WEST SUSSEX COUNTY COUNCIL CONSULTATION

TO:	Arun District Council FAO Ms M Tomalova
FROM:	WSCC - Highways Authority
DATE:	19 February 2020
LOCATION:	15-17 Kew Gardens, Bognor Regis, PO21 5RD
SUBJECT:	BR/27/20/DOC Approval of details reserved by condition imposed under ref BR/63/19/PL relating to Condition Nos 3 - dustbin storage, 5 - renewable energy, 7 - material & finishes, 10 - Construction Management Plan, 13 - cycle parking spaces, 15 - visibility splays and 16 - pedestrian visibility splays.
RECOMMENDATION:	More Information

Project:-	
Proposed Residential Development 15-17 Kew Gardens Bognor Regis West Sussex	
Title:-	
Proposed Visibility Plan (Plots 1,2&3)	
Client:-	
Imperial Homes (Southern) Ltd	
Scale:-	
1:100 (@A1)	
Drawn By:-	Checked By:-
PJD	
Date:-	Date:-
02/03/20	
Job.No:-	Drg.No:-
180037	16
	Rev:-

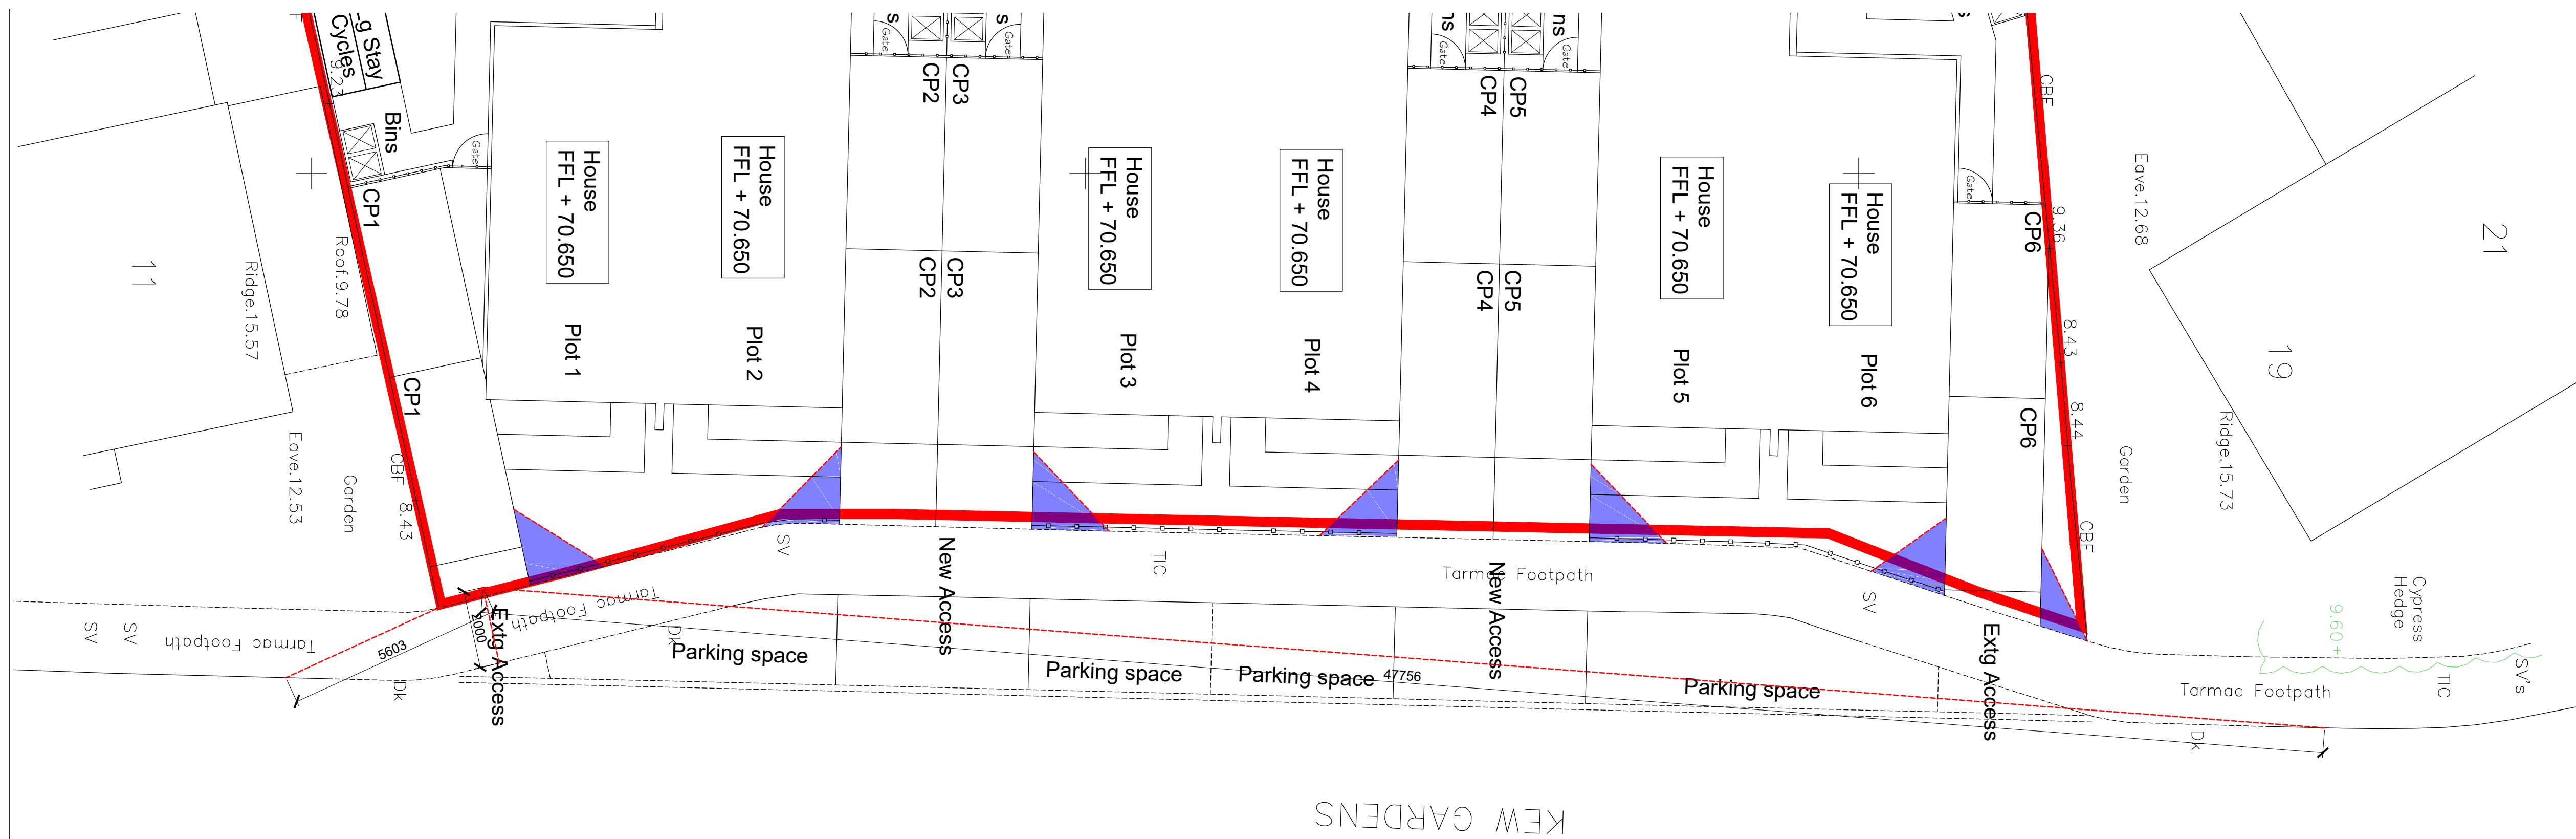
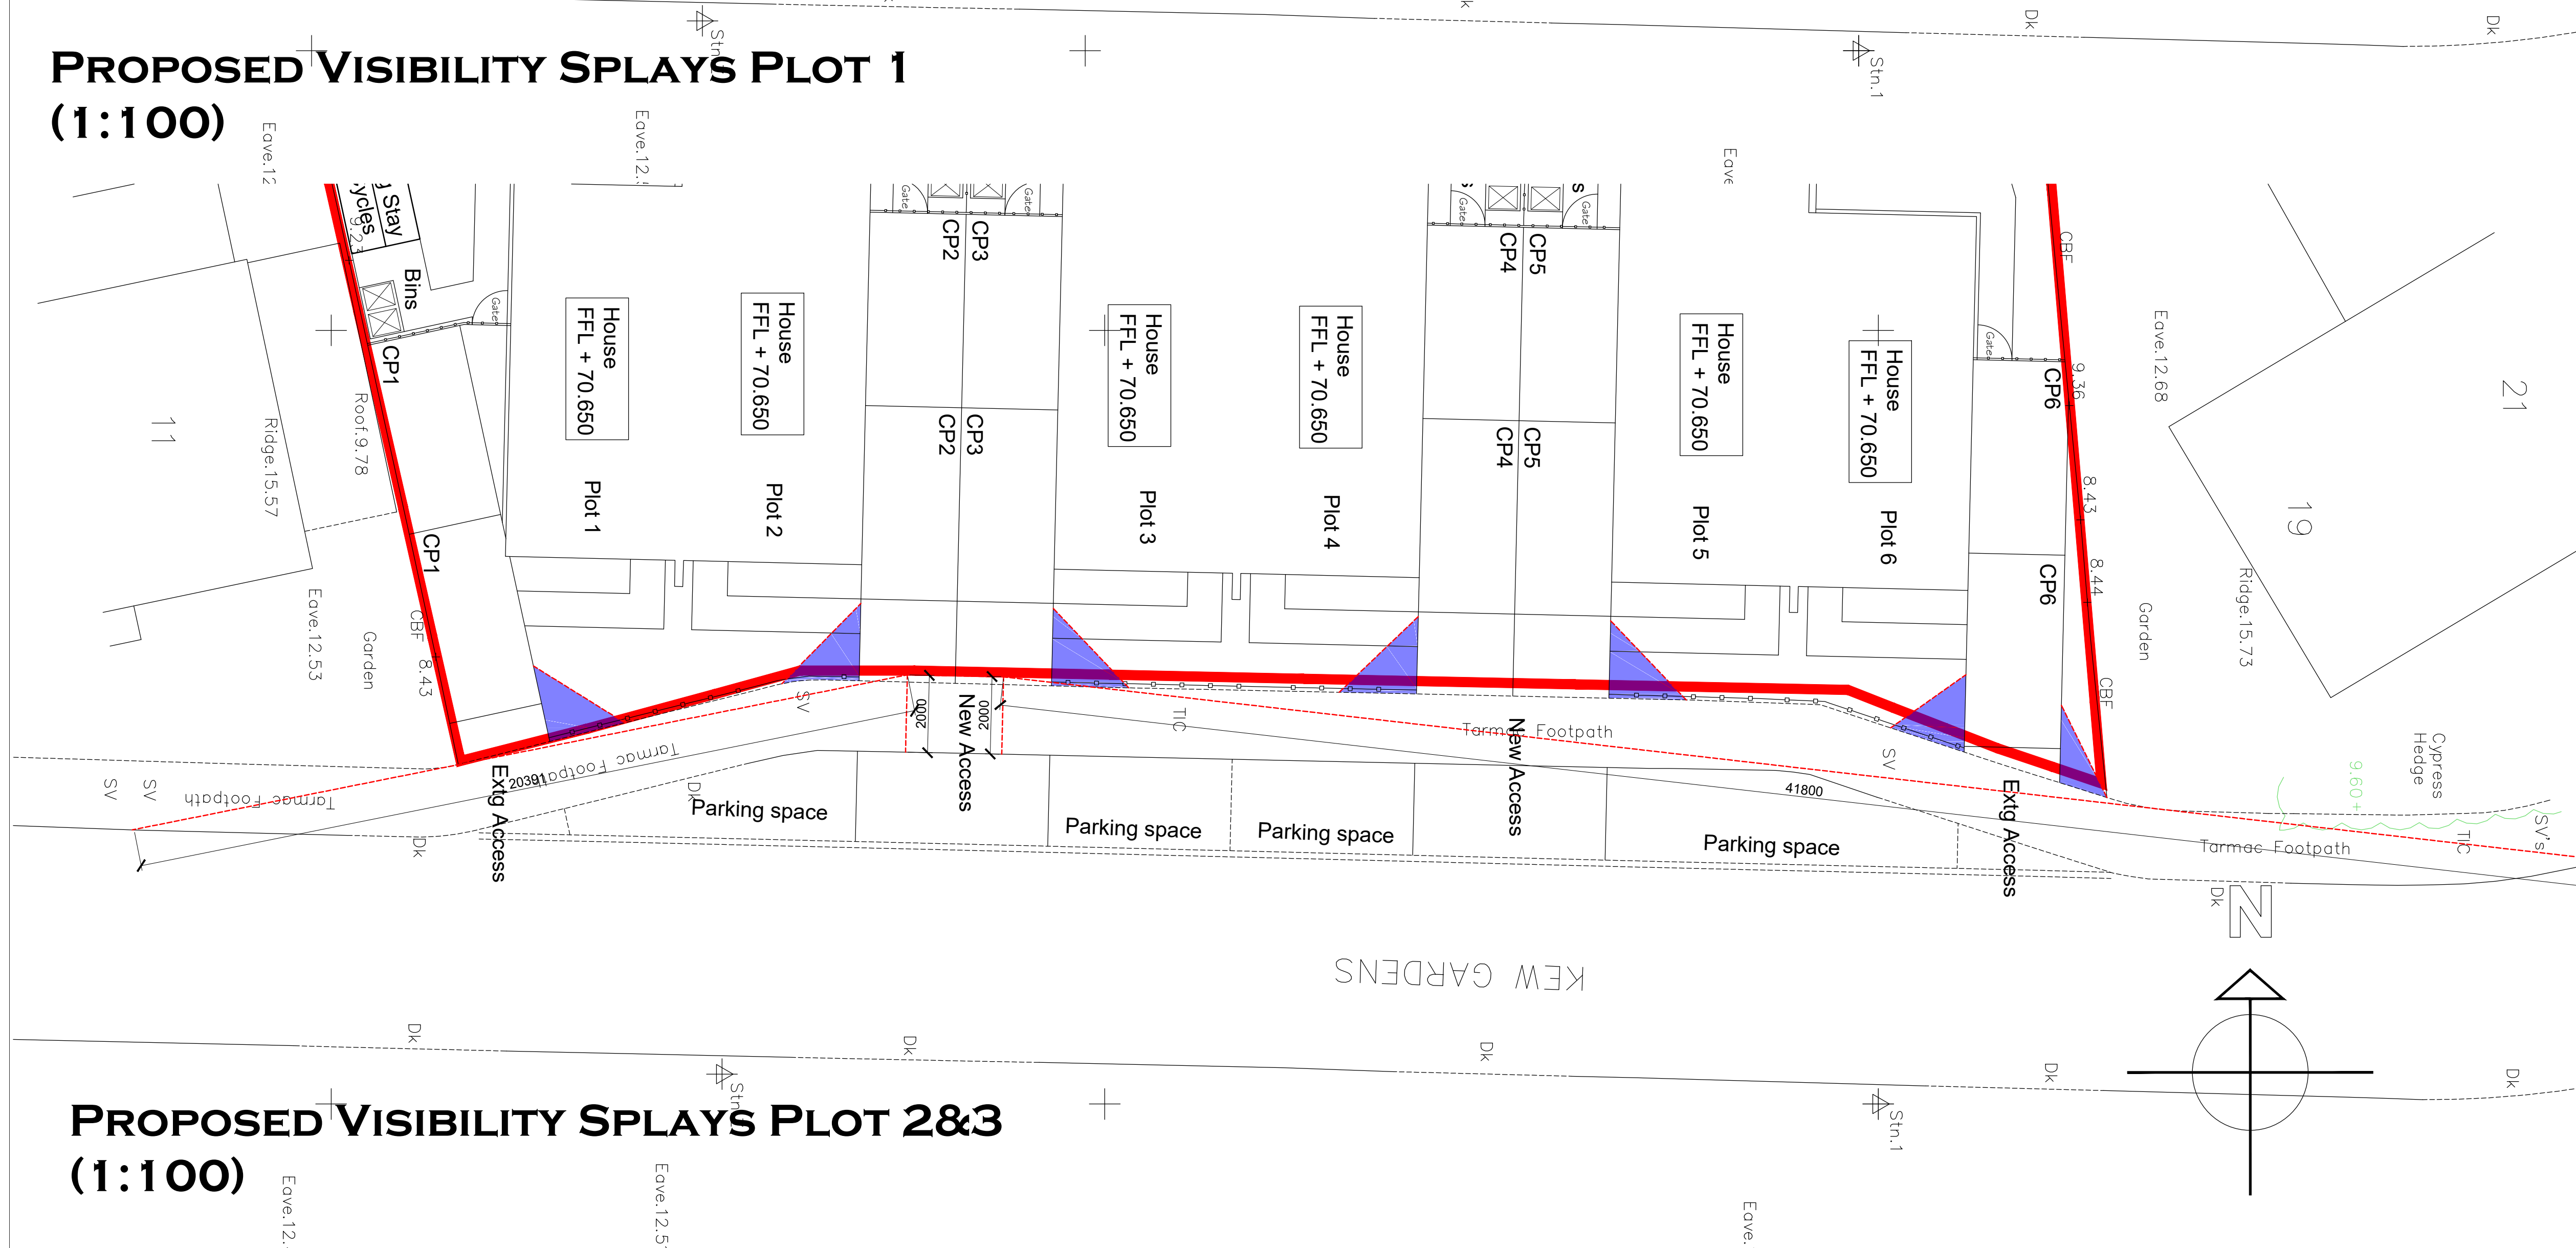
Maximum achievable vehicular visibility splays have been demonstrated from 2m back into each proposed access/car parking space. Considering the anticipated speeds and traffic levels, a 2m 'X' distance is accepted. The full extent of splays for each access point is not clear. The LHA acknowledge that the northern and southern most access points are existing however the splays for the new access points should be clearer with the full extent shown and splays achievable annotated.
